# McCLINTOCK STATION FILING NO. 1A

A VACATION AND REPLAT OF LOTS A & C, McCLINTOCK STATION

JOB NO. 25251.00  
NOVEMBER 8, 2023  
SHEET 1 OF 4 PCD FILE NO. VR2312

JOB NO. 25251.00  
NOVEMBER 8, 2023  
SHEET 4 OF 4 PCD FILE NO. VR2312

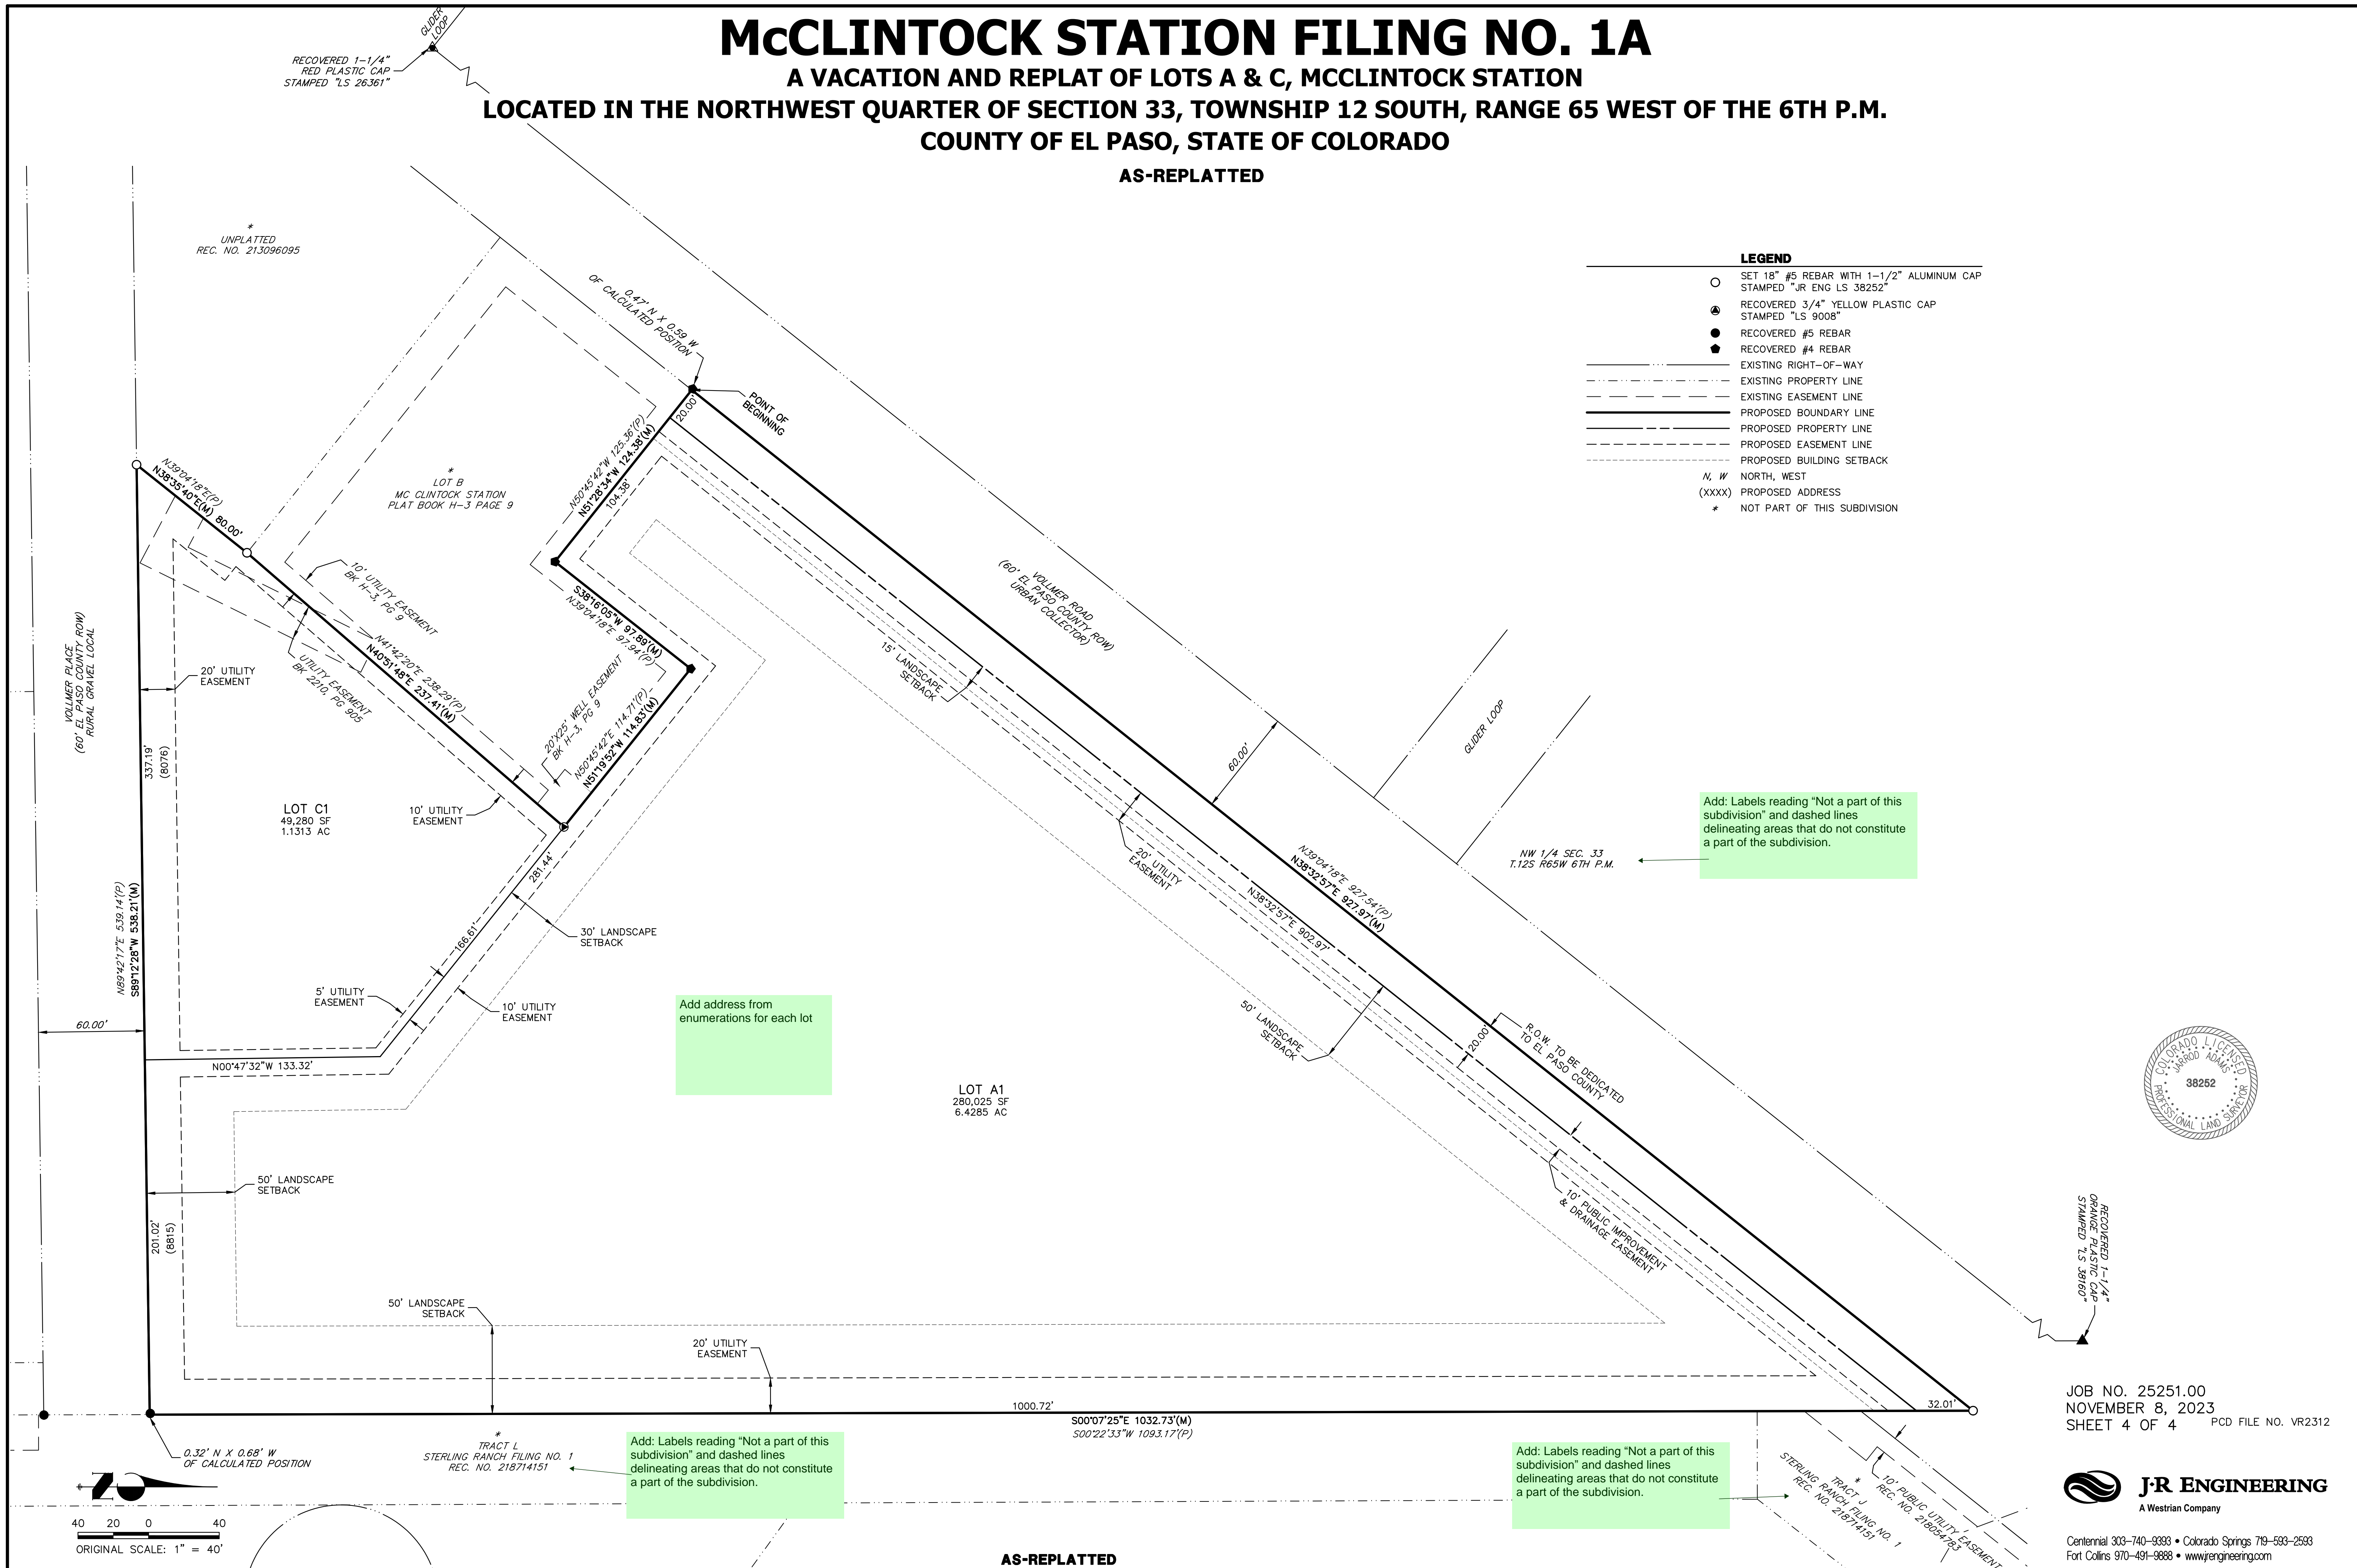
Add: Labels reading "Not a part of this subdivision" and dashed lines delineating areas that do not constitute a part of the subdivision.

Add address from enumerations for each lot

Add: Labels reading "Not a part of this subdivision" and dashed lines delineating areas that do not constitute a part of the subdivision.

Add: Labels reading "Not a part of this subdivision" and dashed lines delineating areas that do not constitute a part of the subdivision.

JR RESPONSE: PLEASE SEE IN THE LEGEND THAT THE "NOT PART OF THIS SUBDIVISION" IS ON THE PLAT AND THE \* DENOTES THAT IS NOT PART OF THE SUBDIVISION. IN ADDITION I HAVE UPDATED THE LEGEND TO SHOW EXISTING RIGHT-OF-WAY AND PROPERTY LINES AS ITS OWN LINE TYPE.

JR RESPONSE: ADDRESSES HAVE BEEN ADDED TO SHEET 807, 805

JR RESPONSE: PLEASE SEE IN THE LEGEND THAT THE "NOT PART OF THIS SUBDIVISION" IS ON THE PLAT AND THE \* DENOTES THAT IS NOT PART OF THE SUBDIVISION. IN ADDITION I HAVE UPDATED THE LEGEND TO SHOW EXISTING RIGHT-OF-WAY AND PROPERTY LINES AS ITS OWN LINE TYPE.

JR RESPONSE: PLEASE SEE IN THE LEGEND THAT THE "NOT PART OF THIS SUBDIVISION" IS ON THE PLAT AND THE \* DENOTES THAT IS NOT PART OF THE SUBDIVISION. IN ADDITION I HAVE UPDATED THE LEGEND TO SHOW EXISTING RIGHT-OF-WAY AND PROPERTY LINES AS ITS OWN LINE TYPE.
